**\*PRE-HEARING STAFF ANALYSIS\***

**Rezoning Petition No. 95-50**

# CHARLOTTE DEPARTMENT OF TRANSPORTATION MEMORANDUM

SUBJECT: Rezoning Petition 95-50: Philemon Avenue and East  
Craighead Road (Revised 5/22/95)

INDUSTRIAL REZONING  
 ABERNETHY LUMBER CO., INC.  
 ABERNETHY LUMBER CO., INC./BOMAR ENTERPRISES, INC.  
 CRAIGHEAD ROAD CHARLOTTE, NC

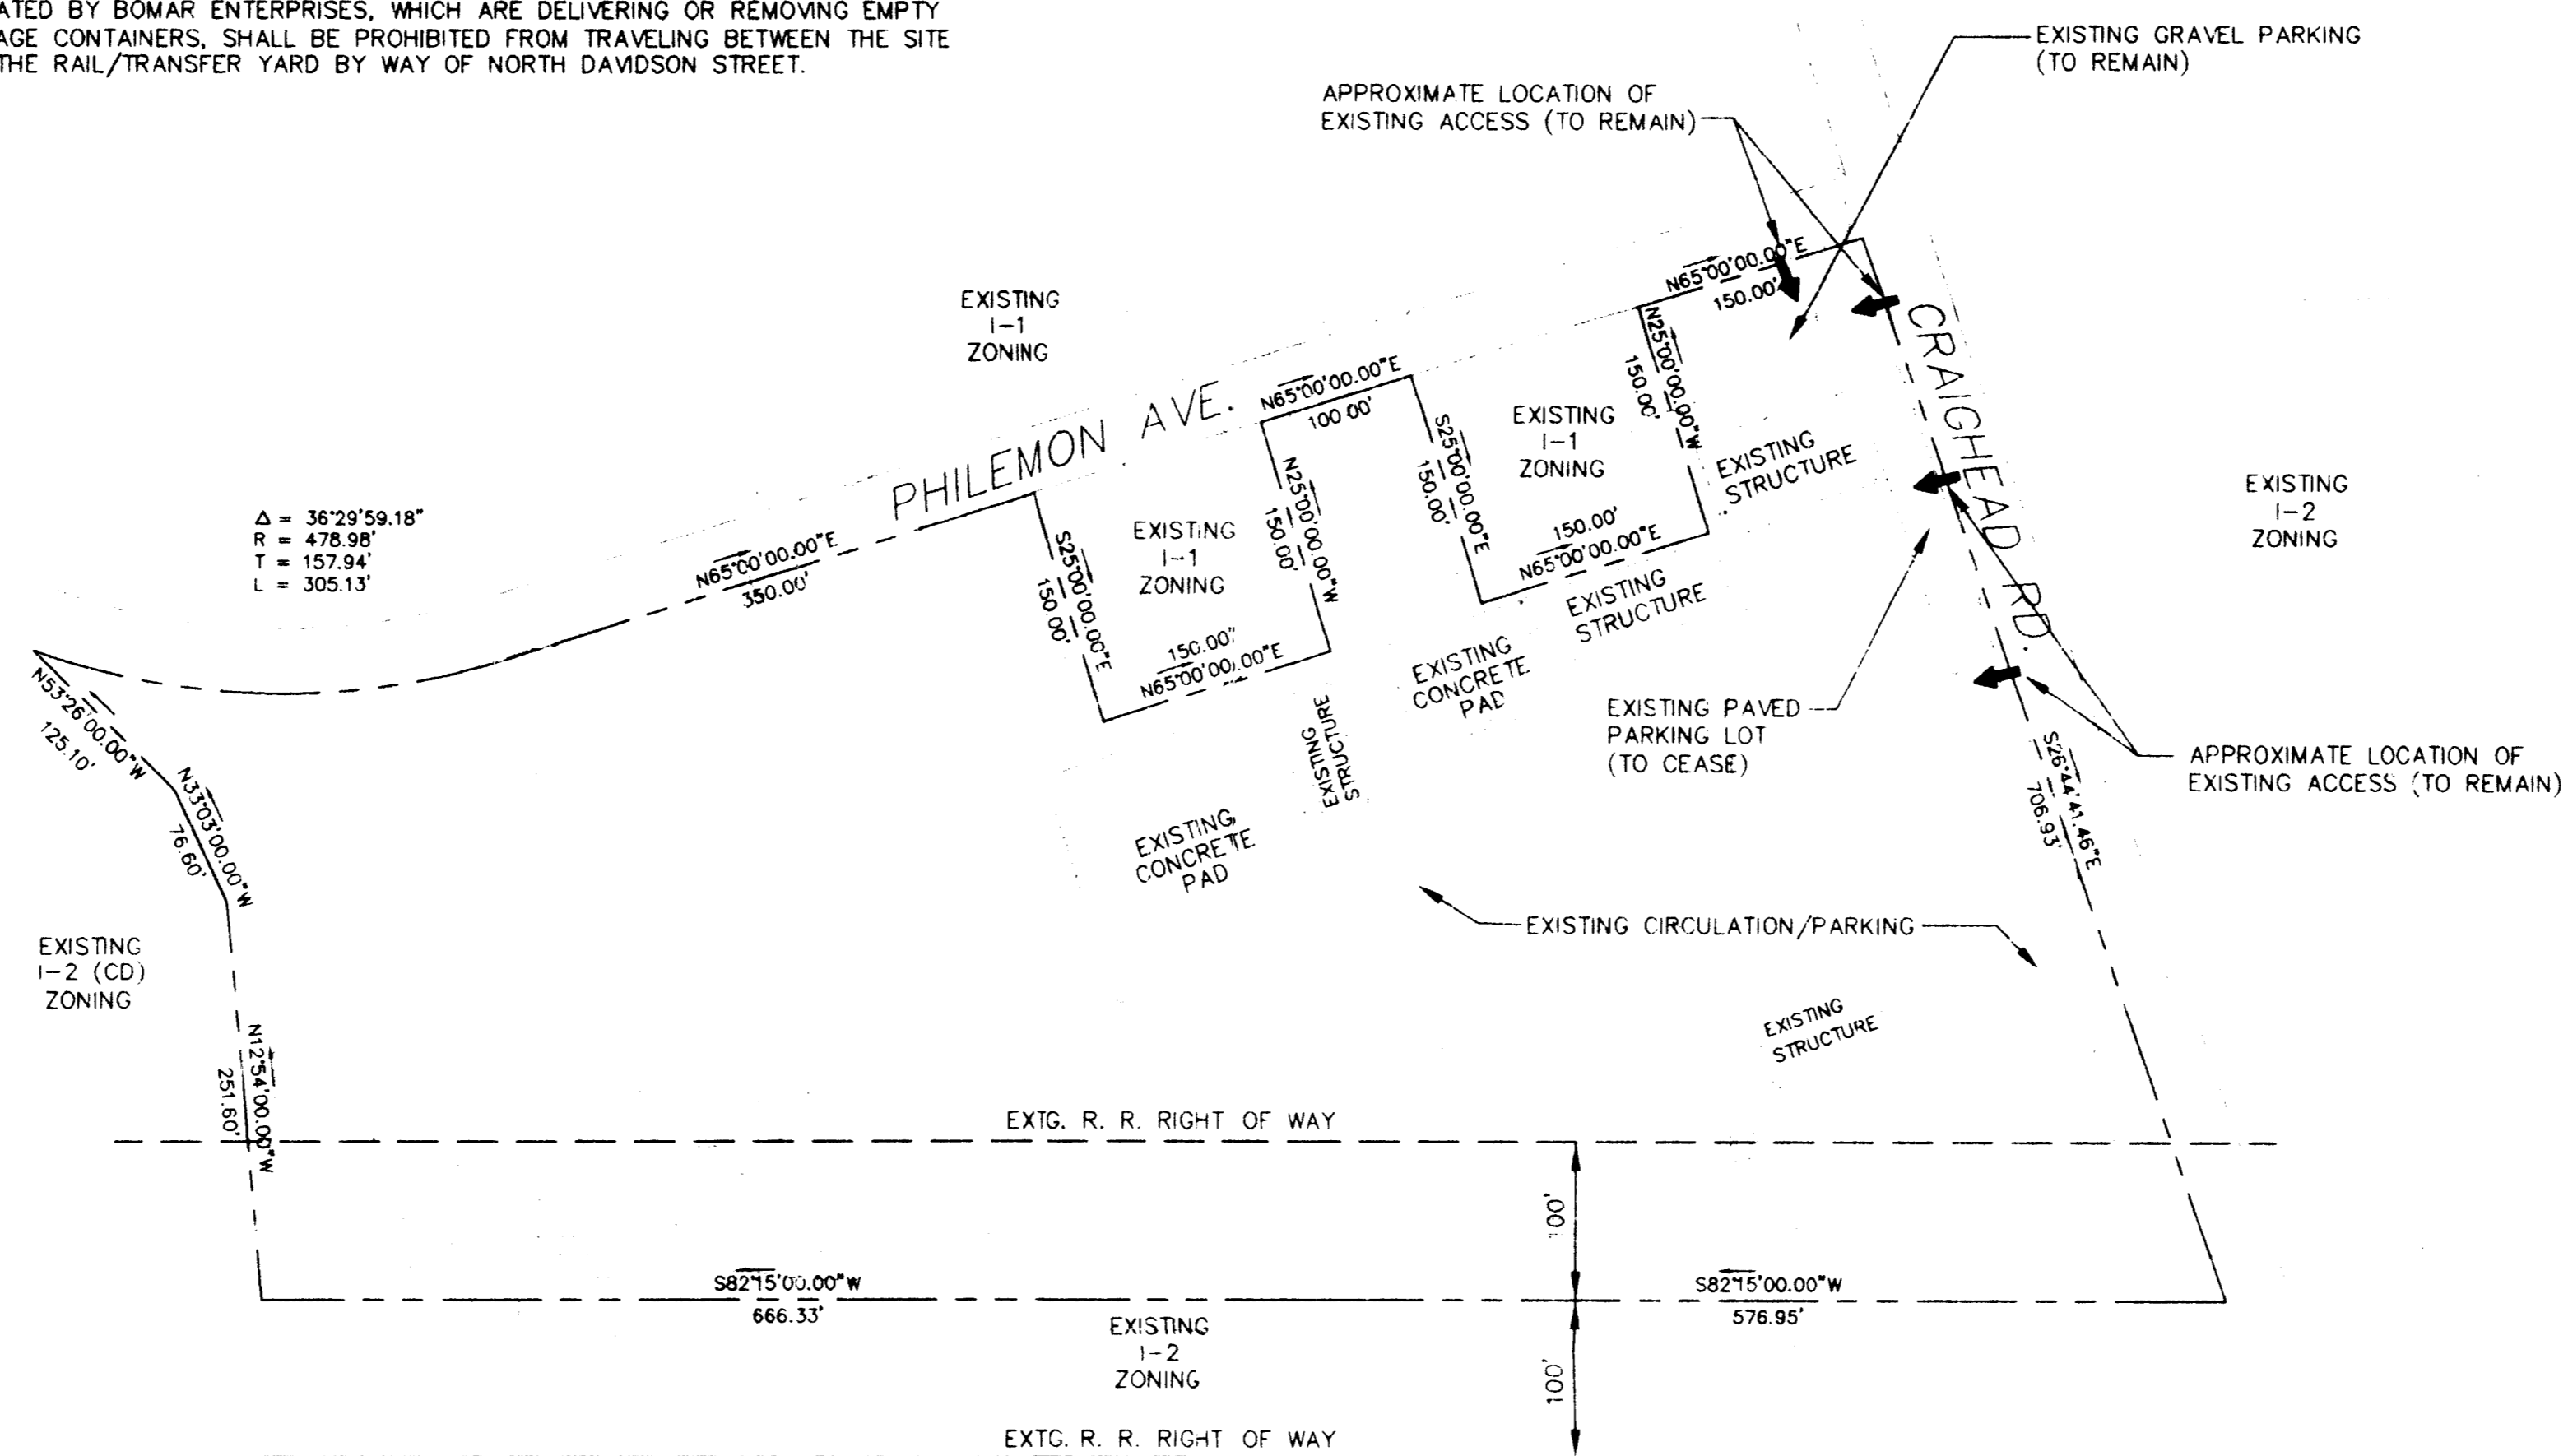
2. **Departmental Comments.** Staff comments noted that outdoor storage and parking are not allowed in the setback, noted that the existing front end parking to the existing structure on Craighead Road which requires vehicles to maneuver in the right-of-way needs to be eliminated and closed off with curb and gutter, and noted that existing structures will not be allowed to become more nonconforming. The revised site plan has addressed some of the departmental comments. Outstanding departmental comments as of the preparation of this report include several transportation related issues noted in the

2. **Site Plan.** The site plan which accompanies this petition would accommodate uses as allowed in the existing I-1 category, a lumber yard, a contractor's office/yard and outdoor storage of vehicles, equipment and materials. The plan notes the existing structures and concrete pads to remain. The plan also notes the existing paved parking lot to remain with the exception of a portion of the parking located along Craighead Road which results in maneuvering in the Craighead Road right-of-way. The plan indicates existing access points to Craighead Road to remain. The site plan is viewed as acceptable for approval but there are several outstanding departmental concerns which relate to nonconforming driveways and the need for curb and gutter to close off the Craighead Road parking area which is to be eliminated.

- A more detailed site plan which more accurately reflects existing conditions should be submitted for building permit and/or driveway regulation review. The plan should detail all access locations and indicate if they comply with current regulations.
- The vacant lot located at the corner of Craighead Road and Philemon Avenue is currently being used for parking and all access locations to this lot must be brought into compliance with the City Driveway Regulations as noted on the revised plan.
- All existing front-in parking to the existing structure on Craighead Road requires vehicles to maneuver in the right-of-way. This parking area is to be eliminated as noted on the revised plan. The Engineering and Property Management Department has recommended installation of standard 2' 6" curb and gutter to close off the parking area.

Adequate sight distance triangles must be reserved at the existing/proposed entrance(s). Two 35' x 35' and two 10' x 70' sight triangles are required for the entrance(s) to meet sight distance requirements. All proposed trees, berms, walls, fences and/or identification signs must not interfere with sight distance at the entrance(s). Such items should be identified on the site plan.

- Dimension width of the existing and proposed driveways. Minimum width for a two-way driveway is 26 feet.
- New/reconstructed driveways must be drop curb ramp Type II driveways (without radii).
- Indicate the locations and widths of all adjacent and opposing driveways.
- Indicate typical parking module dimensions.
- Include a parking summary with figures for number of parking spaces required and provided.
